Address: Manor House Barn Moorhouse Lane Bradford BD11 2AY

Application number: 2021/94599	
What is the application for?:	Erection of 6 dwellings and associated works
Address of the site or building:	Moorhouse Farm, Moorhouse Lane, Birkenshaw, BD11 2AY
Postcode:	BD11 2AY

Client: <b>Mr &amp; Mrs Light</b>	
Project: <b>Redevelopment Proposal Moorhouse Farm Moorhouse Lane, Birkenshaw, BD11 2AY</b>	
Drawing: <b>Proposed Site Layout</b>	
Date: <b>Nov 2021</b>	Scale: <b>1:750 @ A3</b>
Drawing No: <b>2077/110</b>	Rev: <b>C</b>

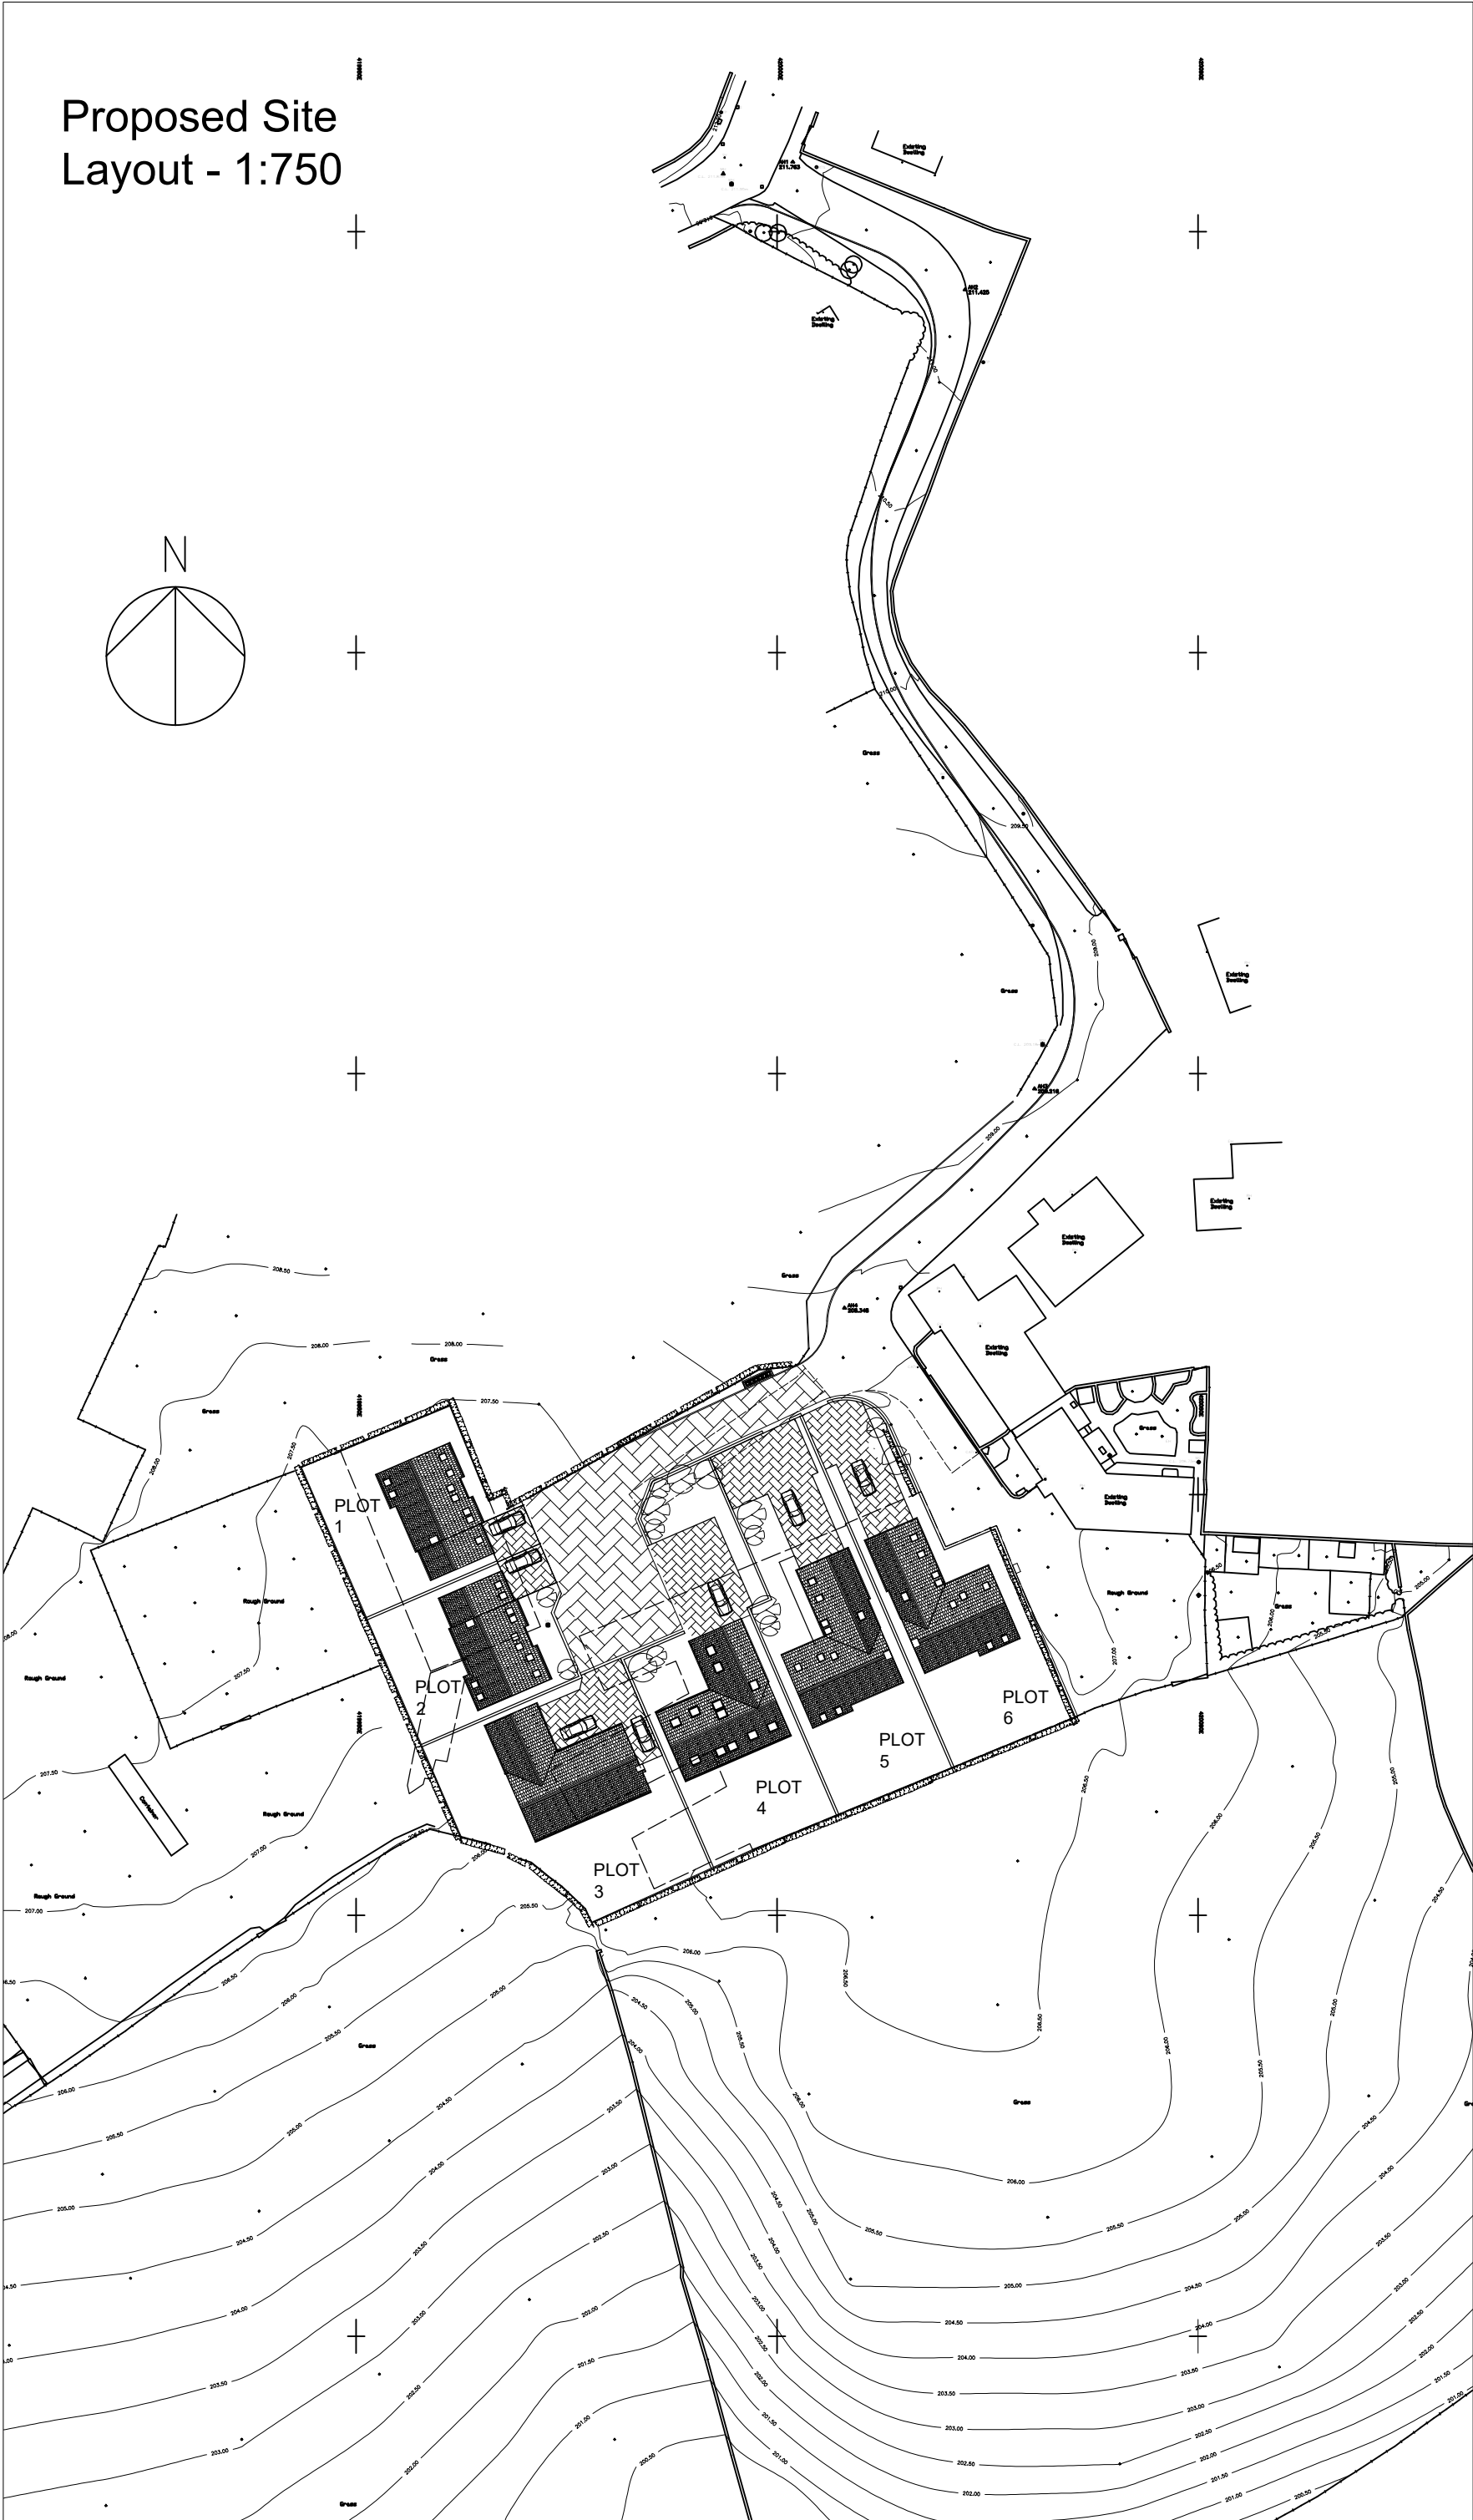
Type of comment: A general comment	
Do you wish your comments to be published on the website anonymously?	No
effect on living conditions - We are not objecting to the new development, my concern regarding the build it that my house faces the site directly and the proposed new development and access road to the new site (as currently shown on the draft plans) face our large barn door/windows. Whilst we feel the vehicles entering wouldn't cause much disturbance, we are very concerned the vehicles leaving the development definitely will. This will result in headlights shining right through our home every time a vehicle leaves the sit. This room is our family room/dining room and where I work from home/ boys study etc. We would ask if this could be looked at to see alternative access to the new development can be made as discussed and following my email.
